CITY OF ALBUQUERQUE

**Re: ITT Building Addition, 5901 Indian School Road NE, Grading and
Drainage Plan**

Engineer's Stamp dated 4-04-05 (J18-D34)

C-1

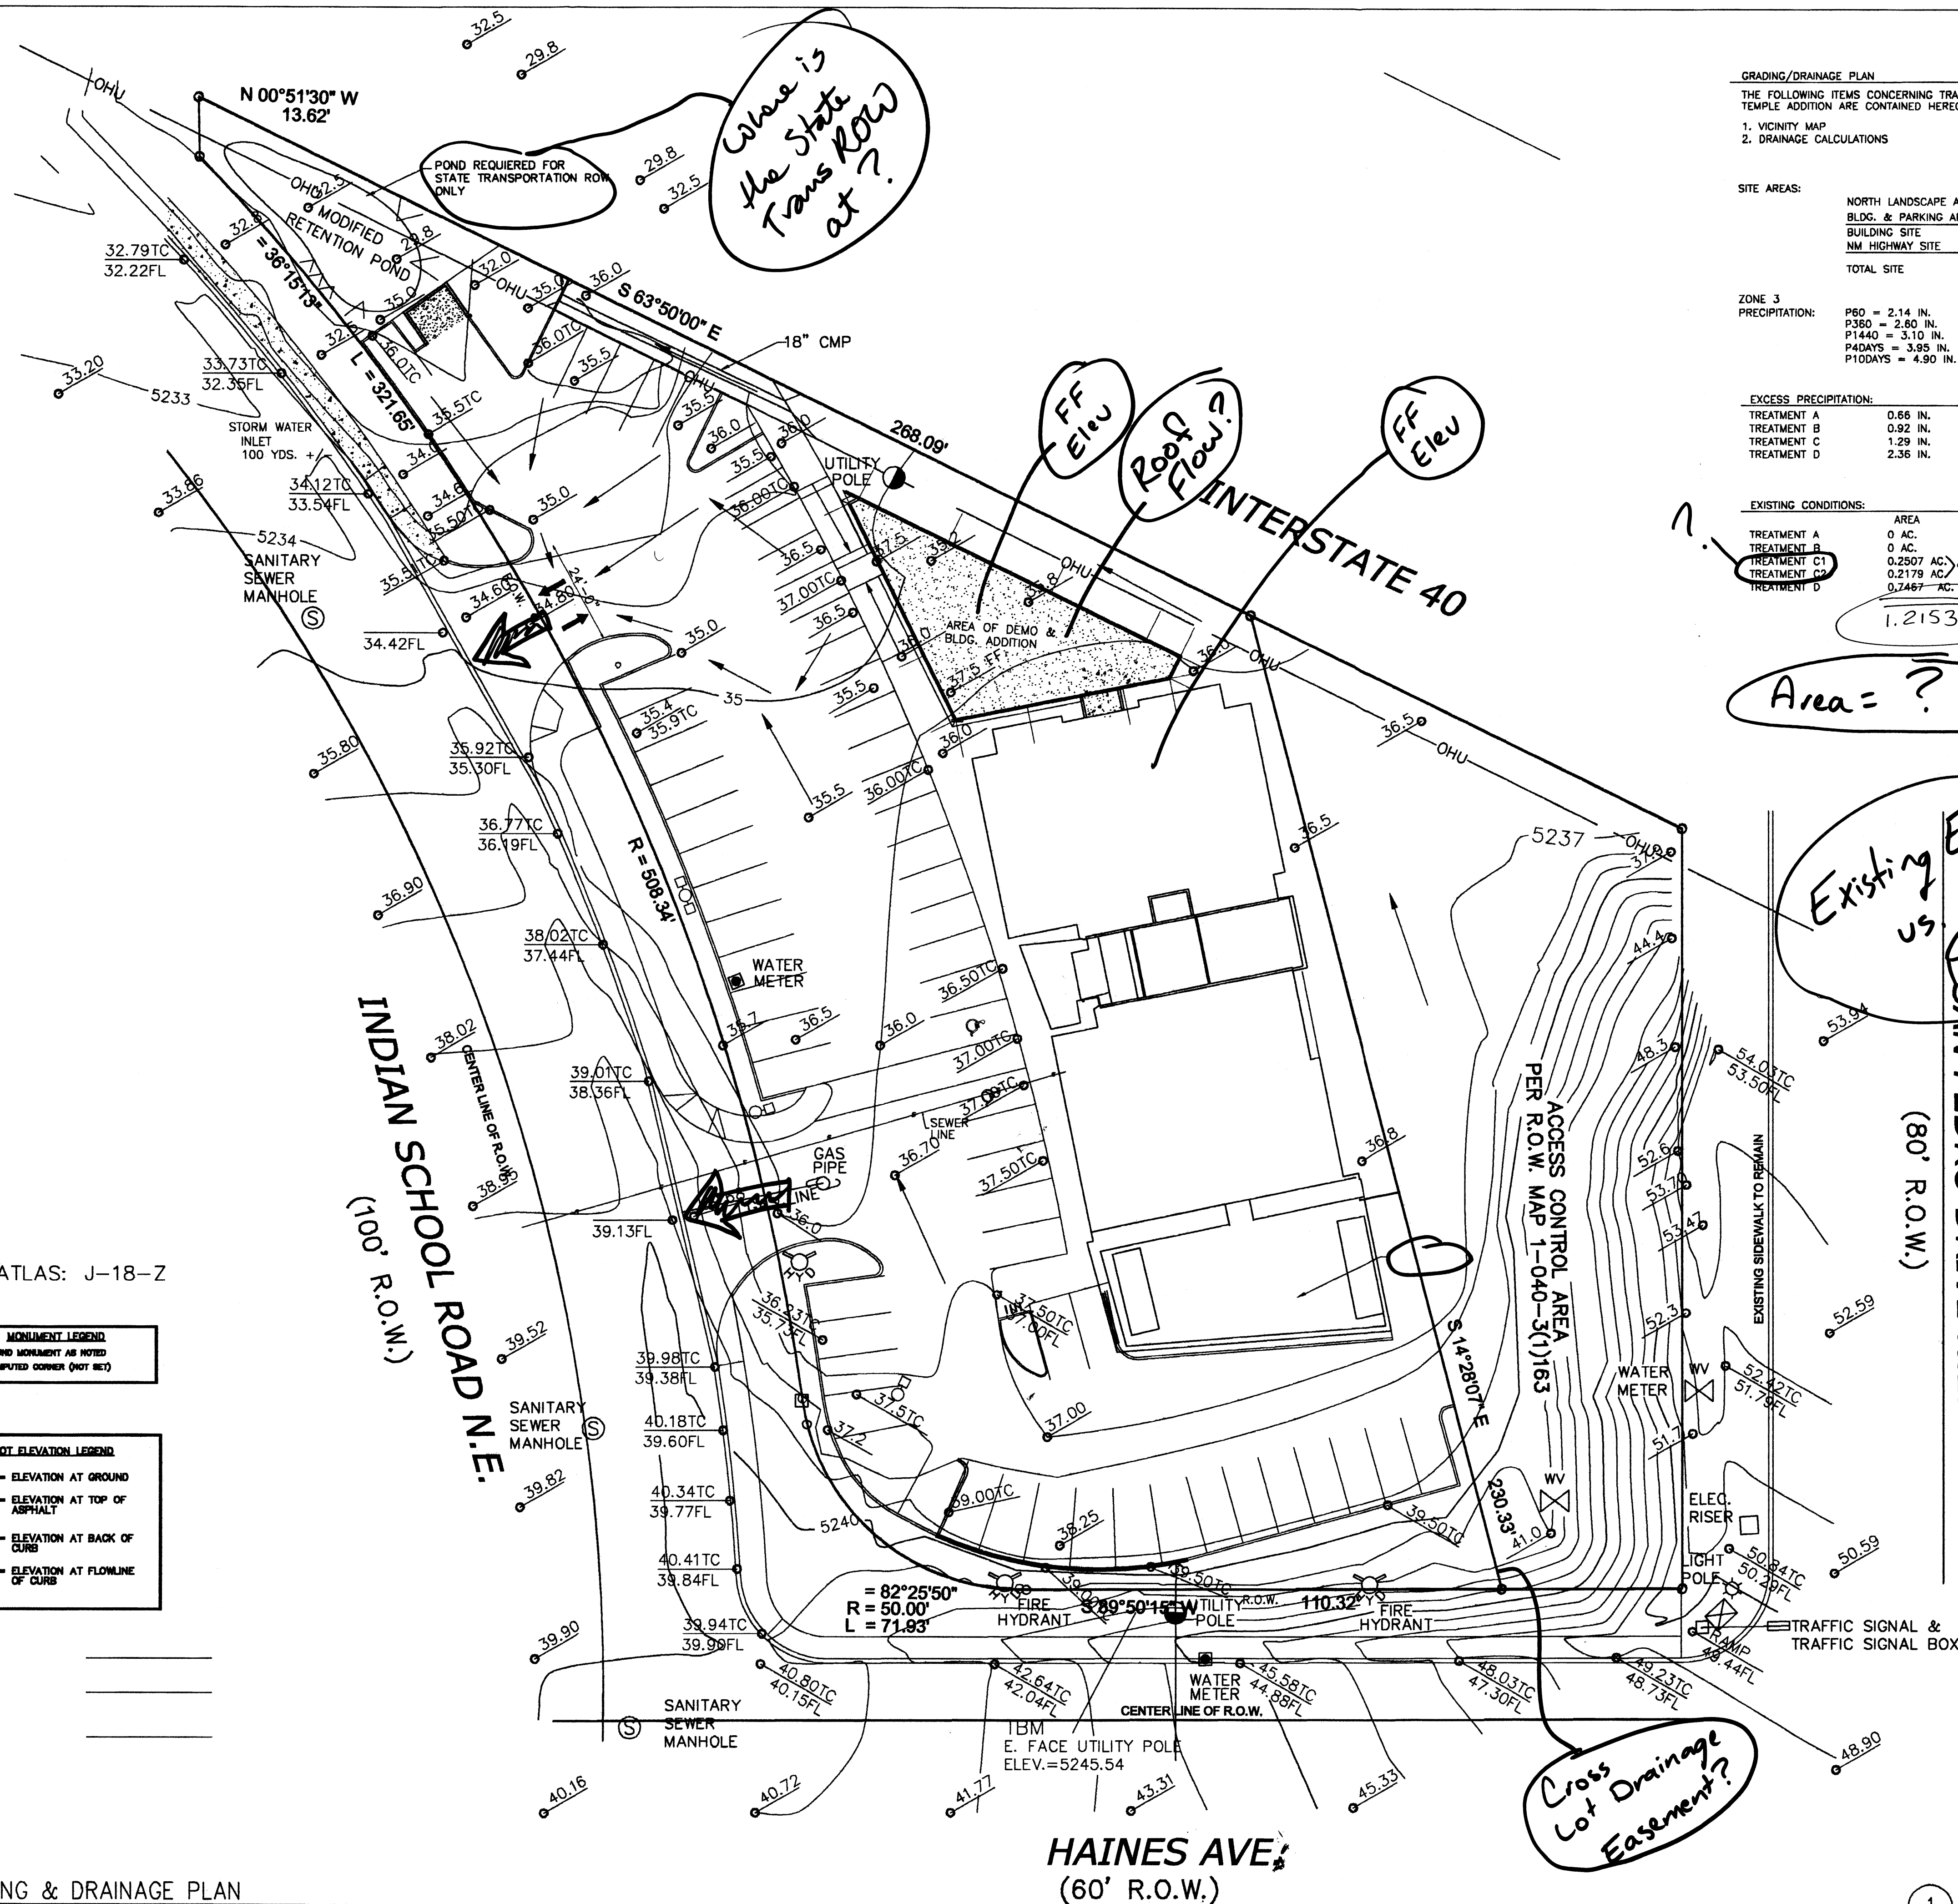
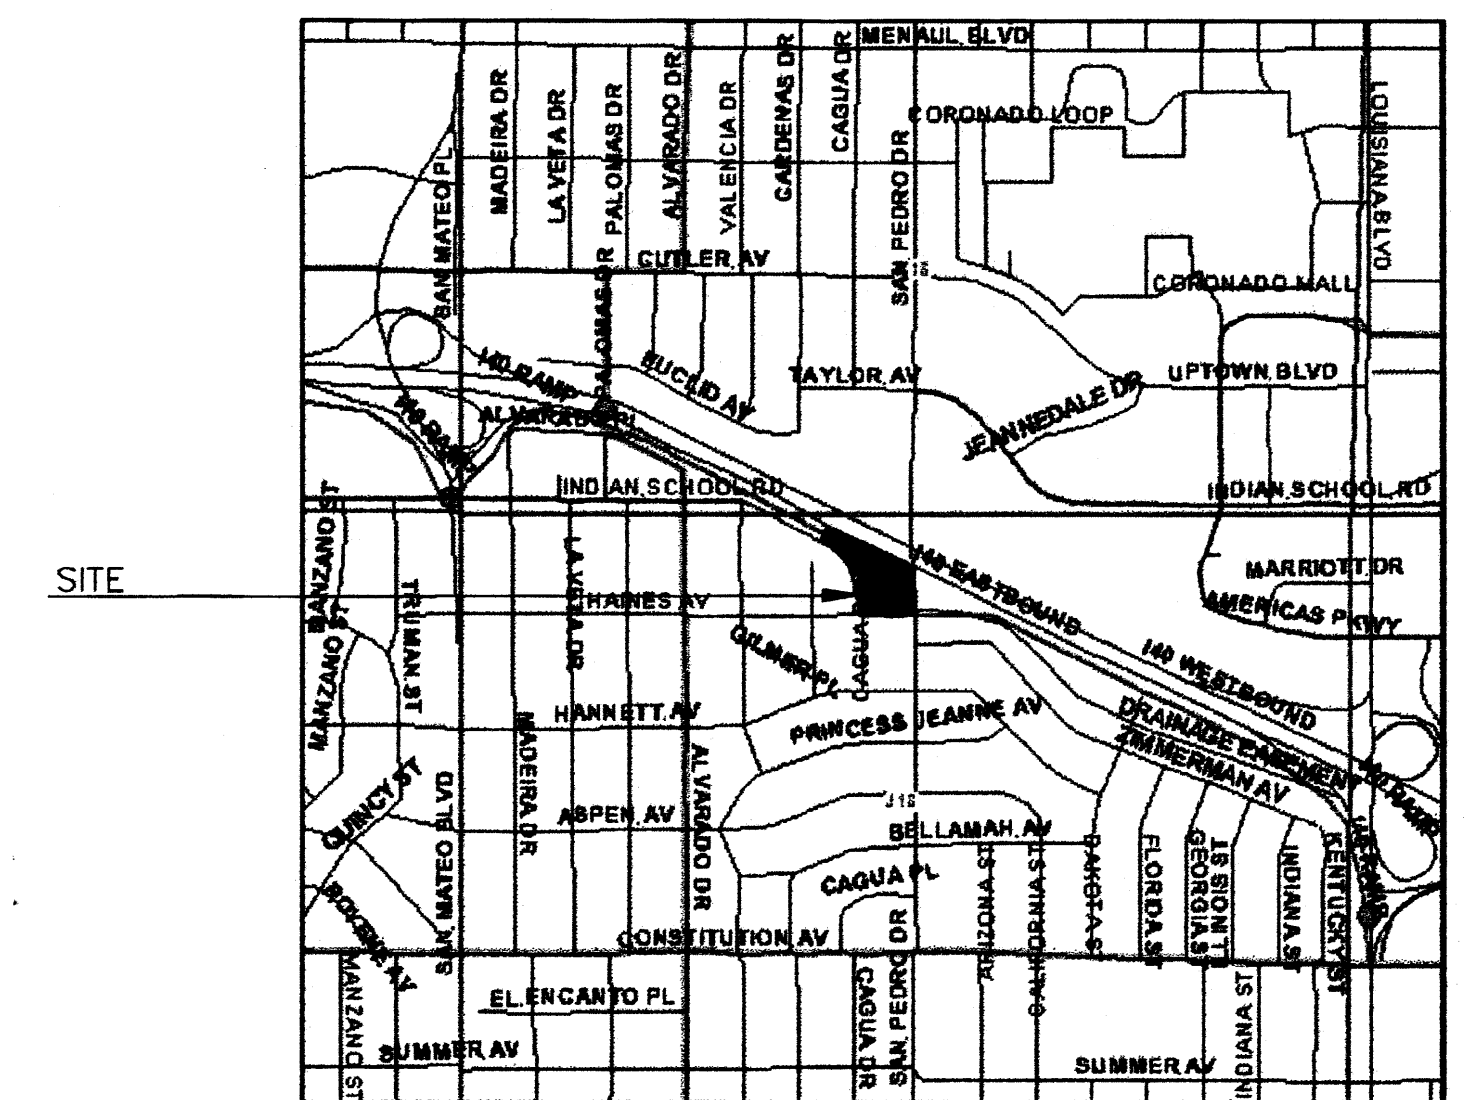
1. No peak flow values (Q_{100}), existing or proposed, are given. Please submit a plan showing all calculations, as well as the existing and proposed flow values.
2. Existing and proposed conditions do not currently agree with the defined total area. It appears that the NMSHTD owned property is counted within the "area – building" as well as the "area – state property."
3. Why is the peak discharge to the pond reduced with a factor of 0.65? I know of no reason why the discharge would have a reduction factor.

C-1

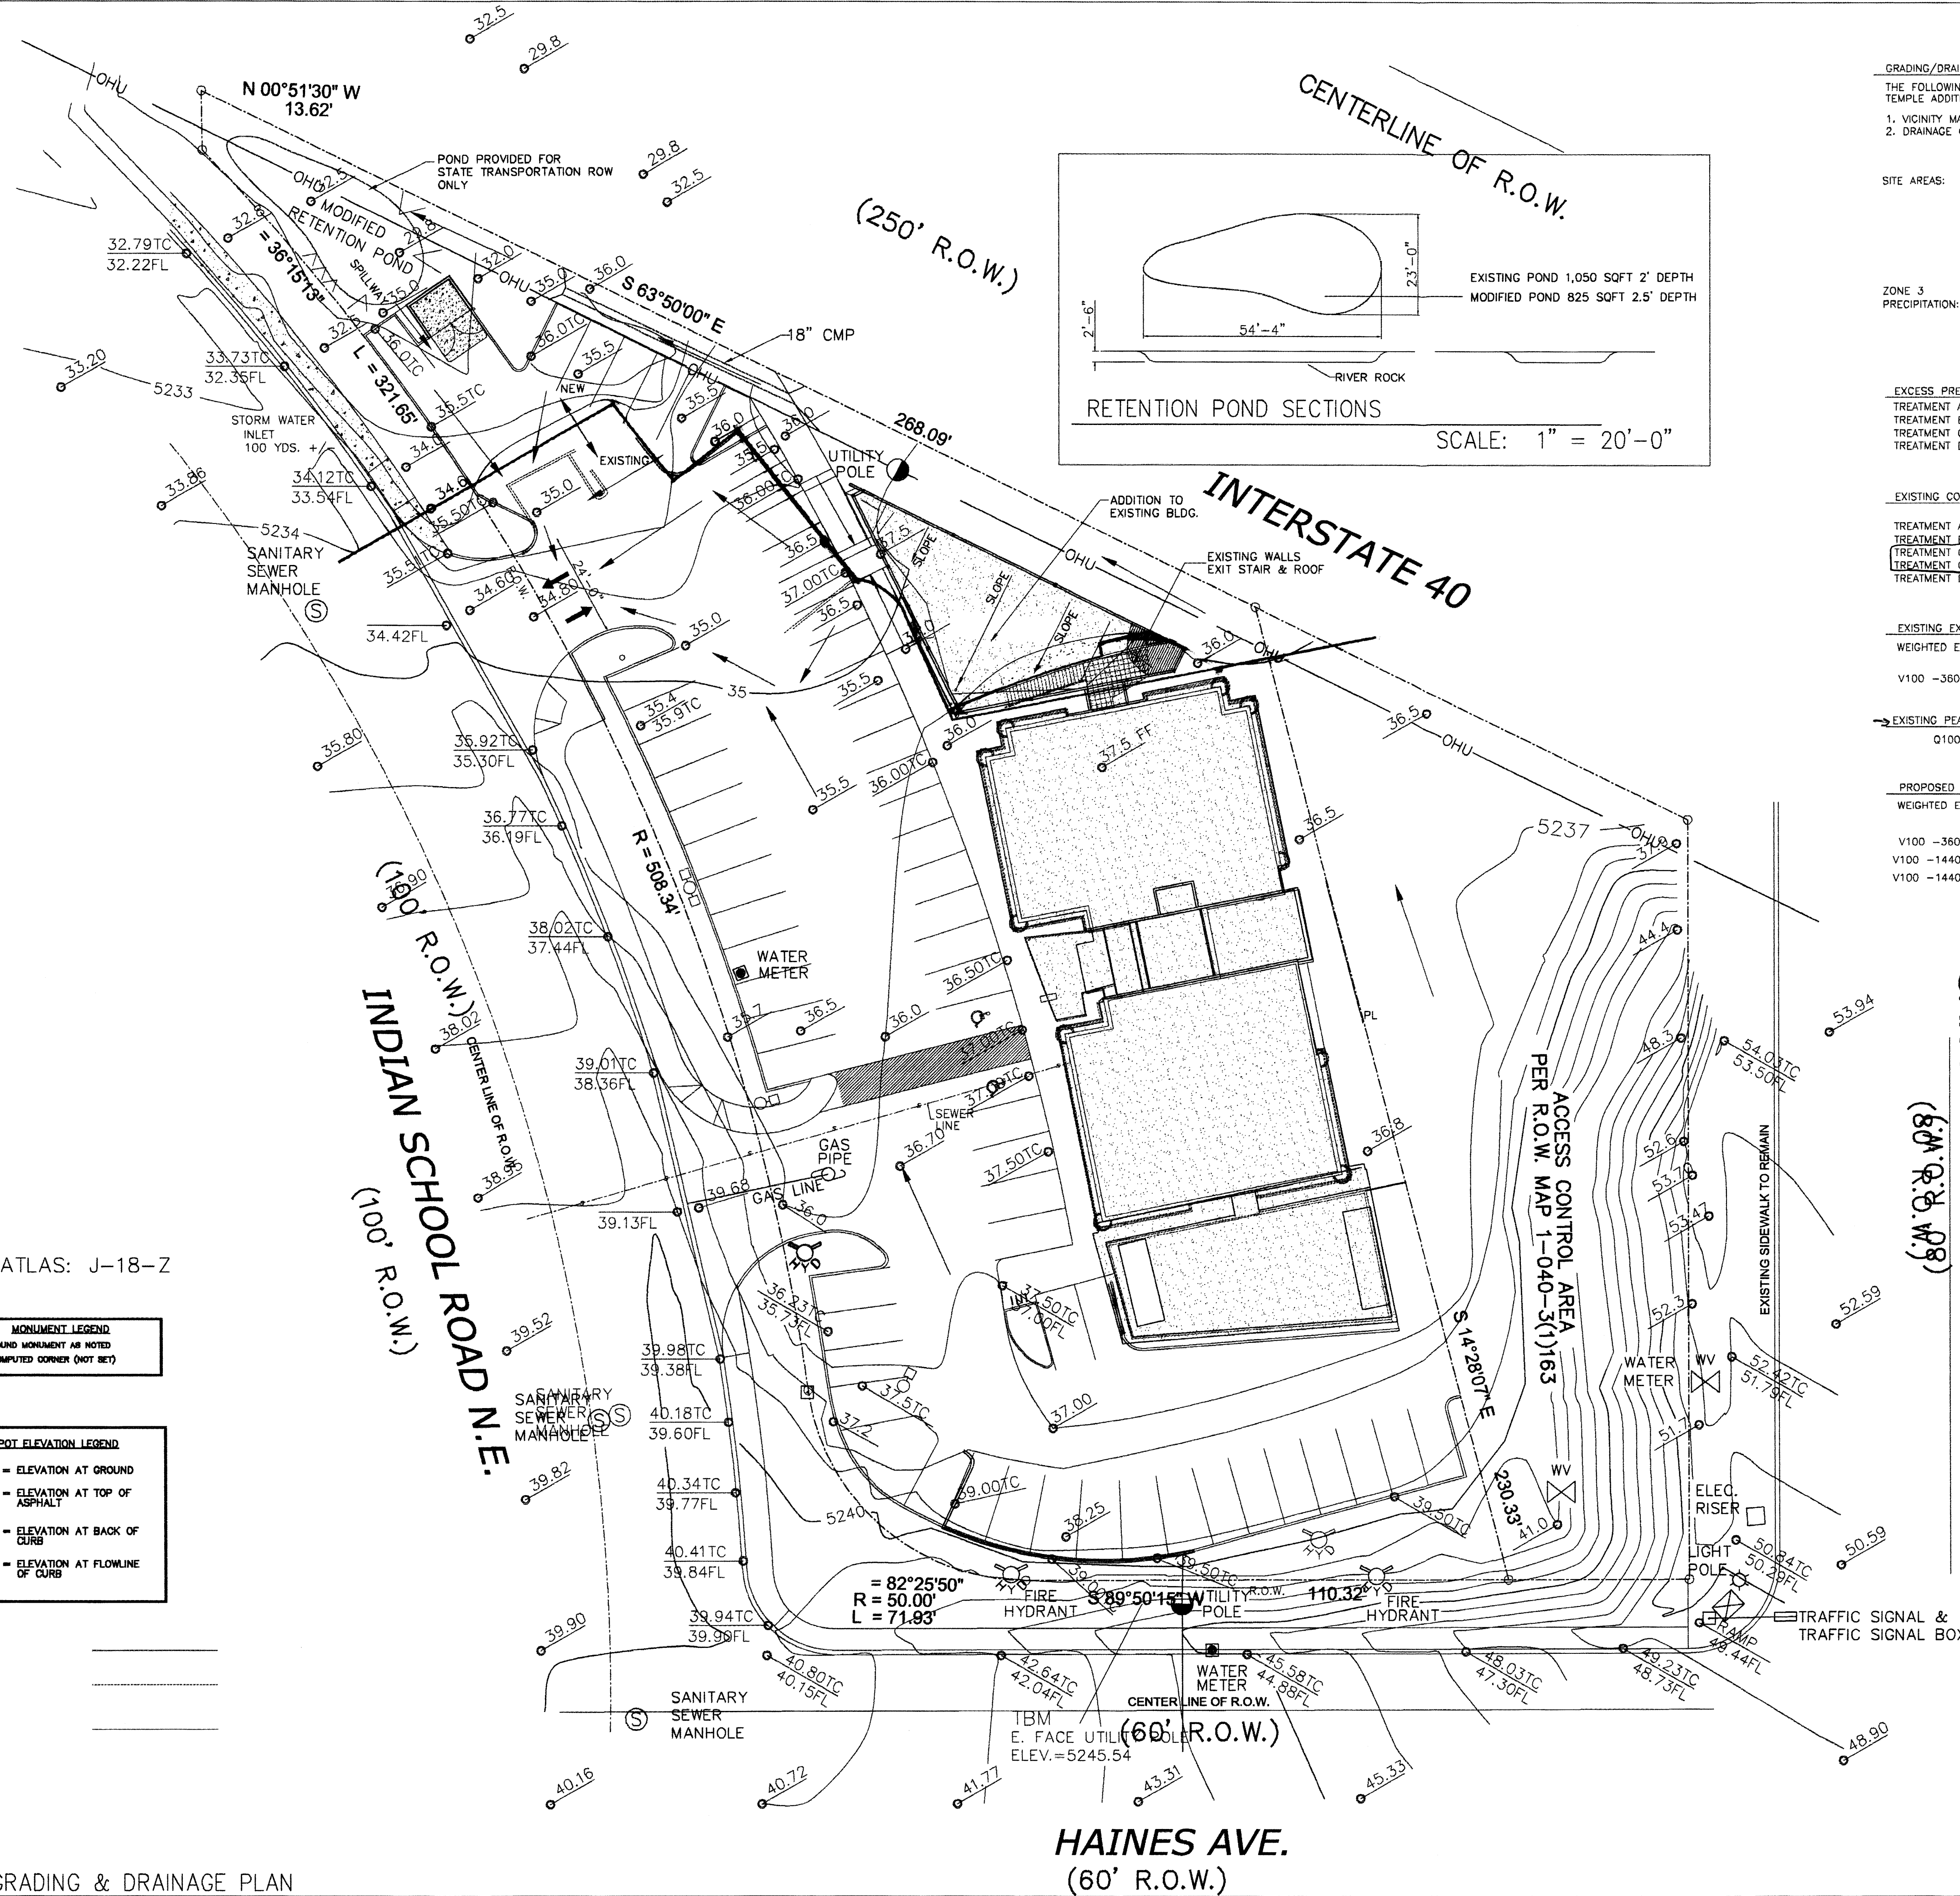
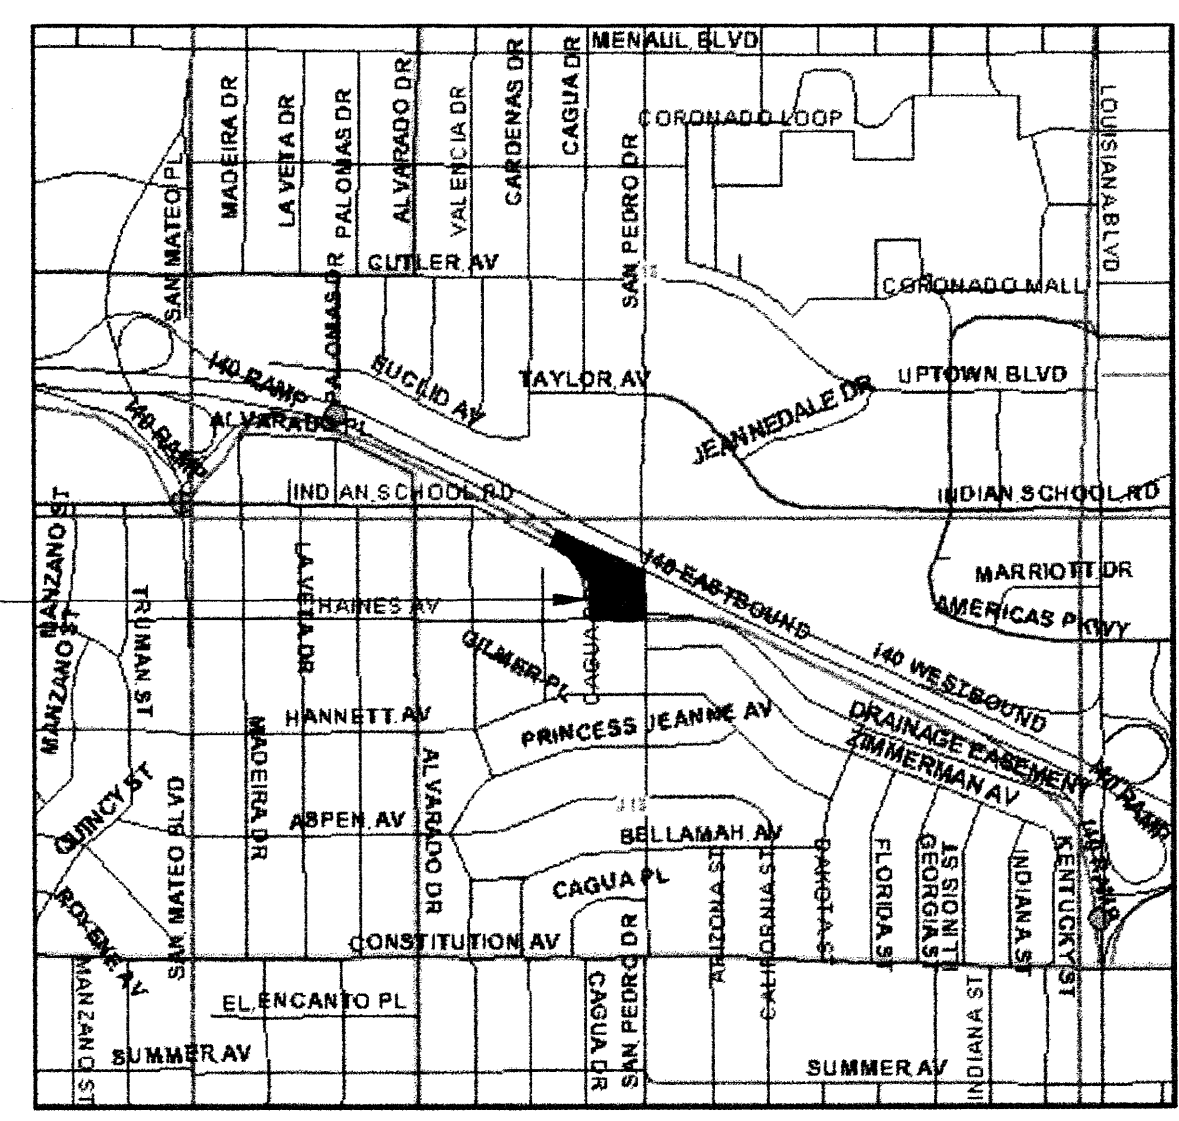
1. What is the actual area of the site? Different areas are shown for existing conditions, proposed conditions, and within the summary.
2. Calculate the proposed peak discharge for the entire project area. The 100-year, 10-day volume must be analyzed for the access control area in order to size the retention pond.
3. More information is necessary for the pond, including the volume and water surface elevation. The pond must have an emergency spillway to the street.
4. It is unclear which areas are existing and which are proposed. Please note that the summary references a re-grading to guide all flow to Indian School Road, and we will need to see the extents of this re-grading.
5. Define the limits of the State Transportation Right-of-Way.
6. Show the roof flow for the proposed building. It must be directed to the parking lot; this must be shown on your certification.
